Your ref: 3/2025/0801
Our ref: UK0042238.5433
24 December 2025

PROPOSED ERECTION OF NEW RESIDENTIAL DEVELOPMENT COMPRISING 80 NEW HOMES, INCLUDING 30% AFFORDABLE HOUSING, OPEN SPACE AND ASSOCIATED INFRASTRUCTURE AT LAND AT SALESBURY VIEW, WILPSHIRE (LPA REF: 3/2025/0801)

Following the submission of the above planning application on 01 October 2025, relevant drawings, plans and reports have been updated to account for consultee responses and additional information which became available following the planning submission. Please see **Appendix 1** attached to this letter for a full list of the plans to be replaced by those submitted with this letter.

Drawing Title:
**SCHEMATIC DRAINAGE
LAYOUT
SHEET 2**

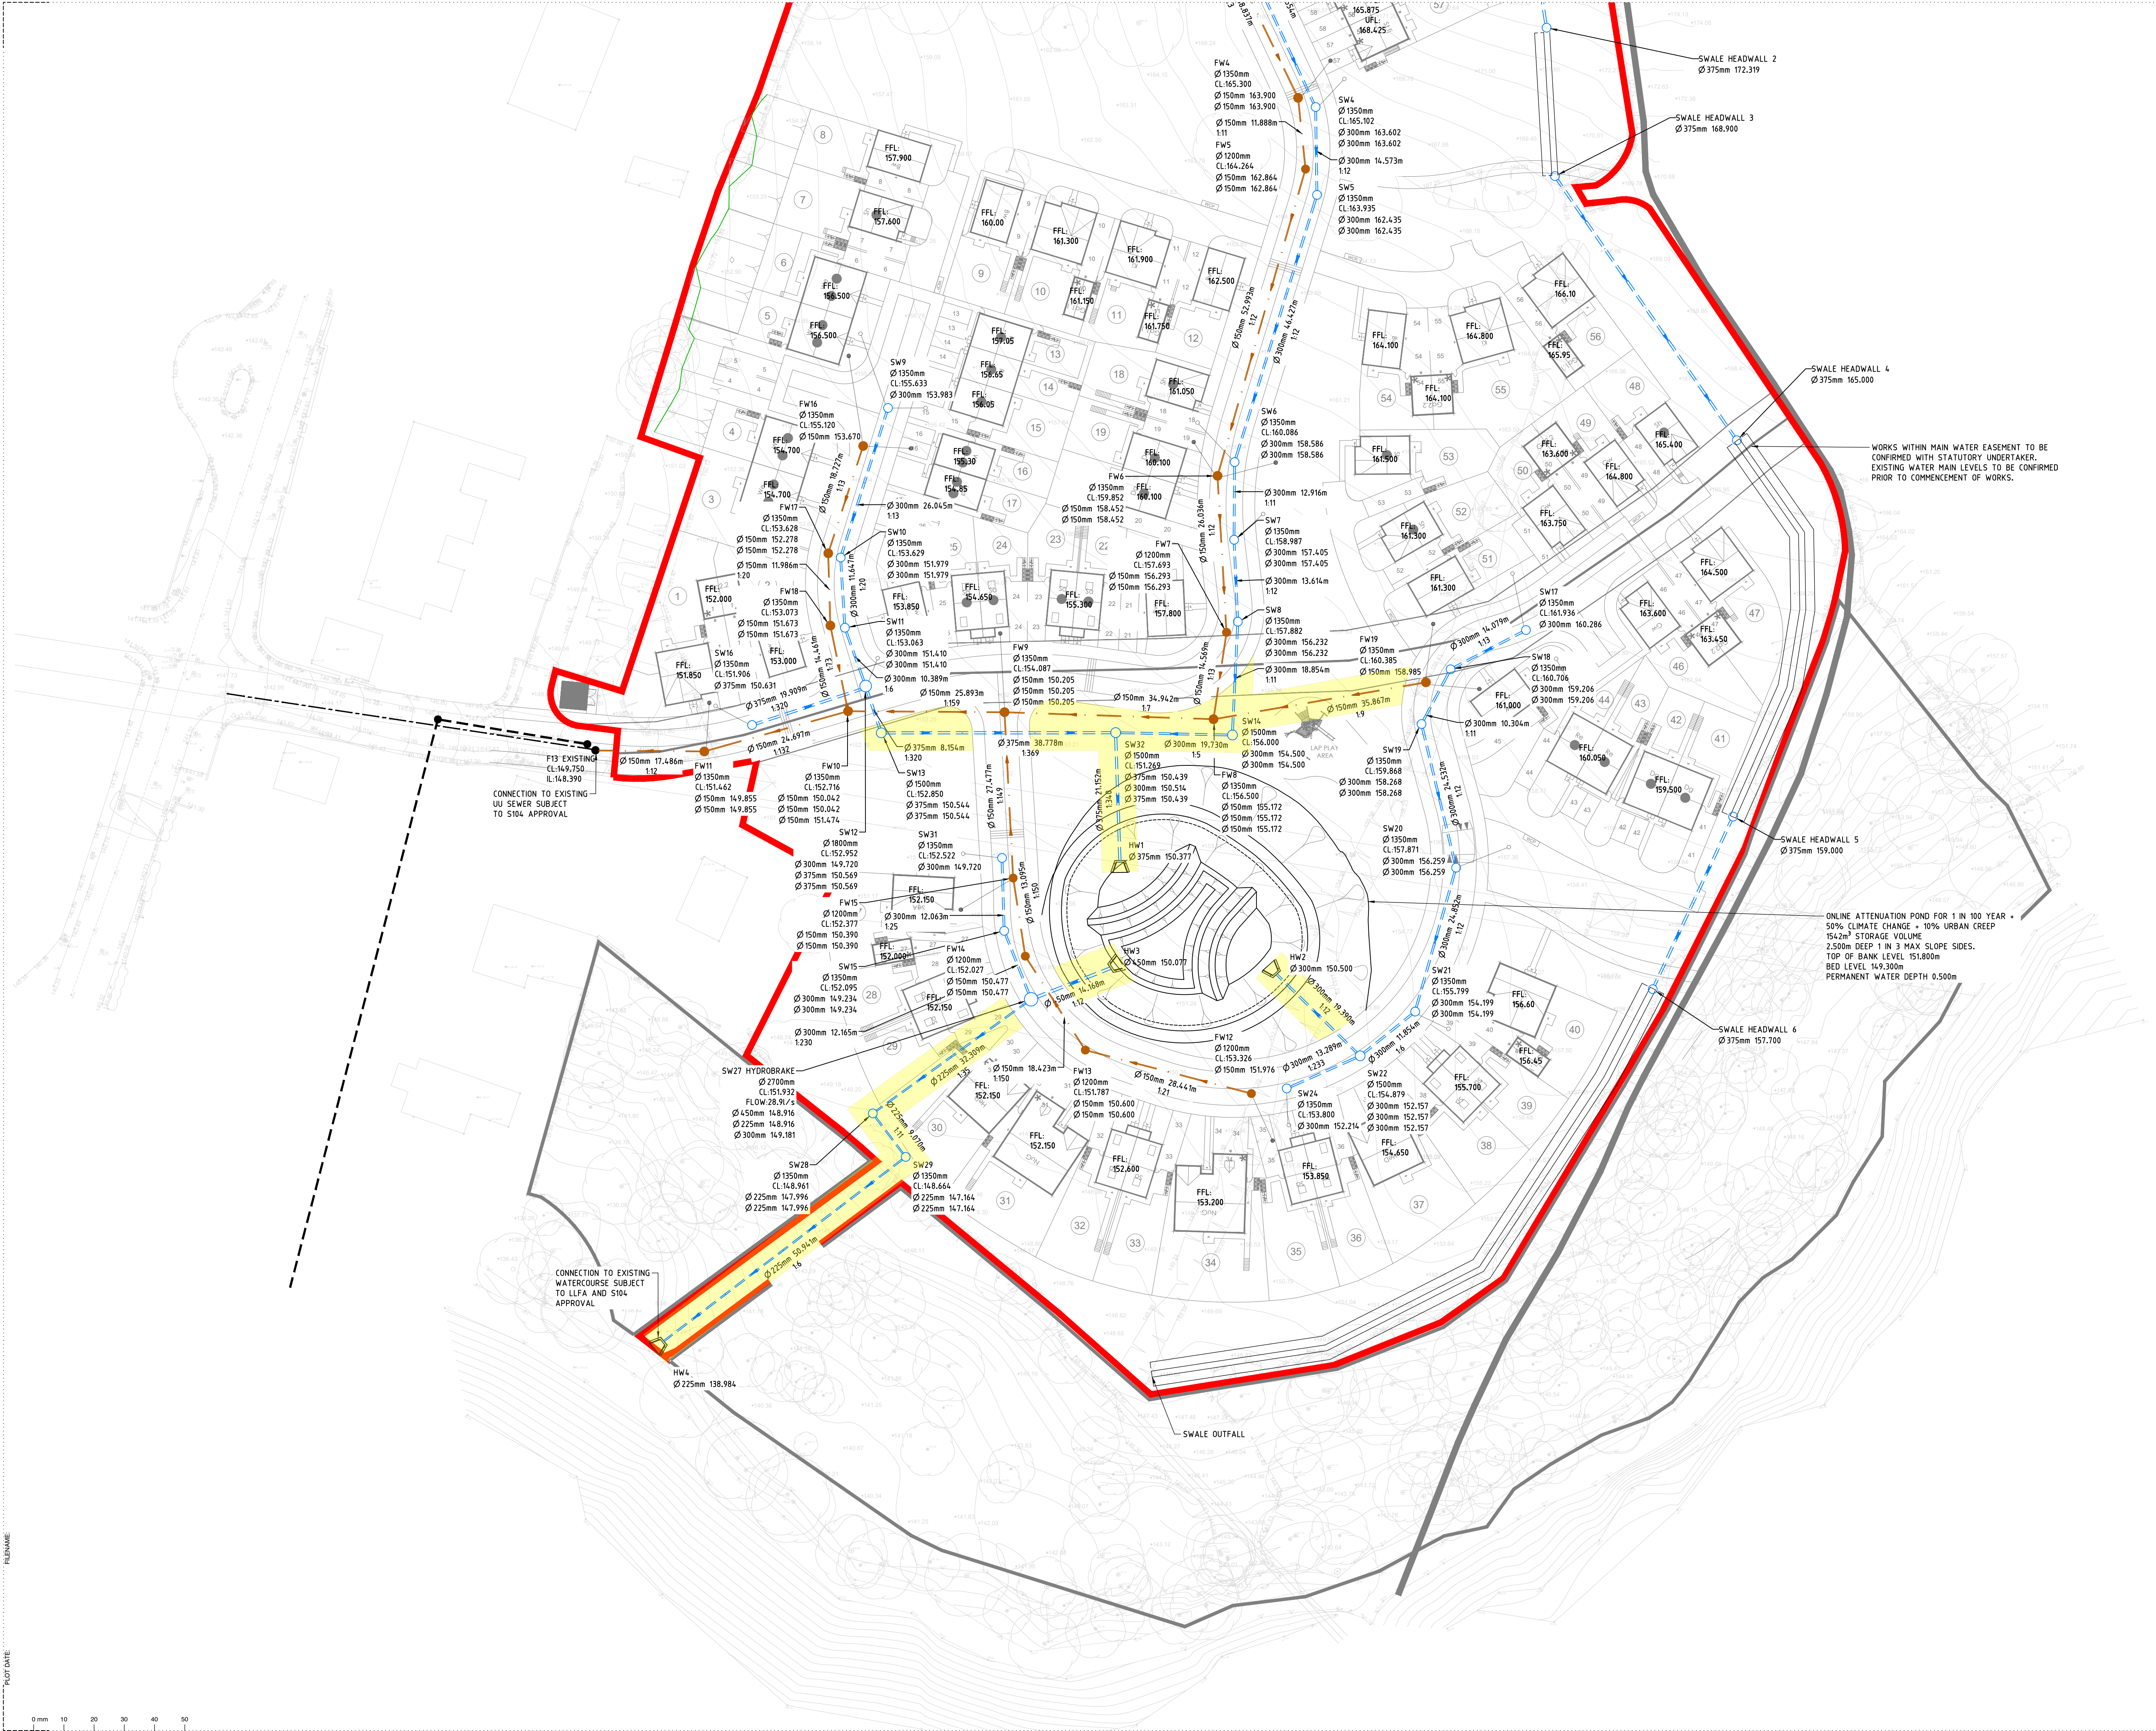
The Lead Local Flood Authority (LLFA) and United Utilities (UU) objected to the proposal requesting additional information. Additional information has been provided to address their queries and concerns; these documents confirm that the proposed development layout does not impact or negatively affect United Utilities asset. Additionally, the proposed drainage strategy has been modified in accordance with the changes to show runoff rates and storage volumes. The documents include:

- Schematic Drainage Layout Sheet 2 (ref: 210687-EDGE-XX-XX-DR-C-2098 P13)
- United Utilities Response (ref: 210687-EDGE-XX-XX-CO-C-0002_UU RESPONSE[P01])

- A swale has been included within the site to provide a net gain in watercourse units on the site in line with biodiversity net gain requirements;
- Proposed planting along the eastern boundary updated to reflect new swale;
- Additional drainage has been added on the eastern and southern boundaries of the site to provide improved drainage;
- The drainage layout has been amended between plots 29 & 30;
- Plots 27-40 to the South of the site have been reconfigured slightly to account for the overhead line and amendments to the drainage layout;
- Some slight amendments have been made to the levels on the site and retaining walls to make sure the most efficient design is presented; and
- The addition of 11 visitor parking spaces to align with previous submission.
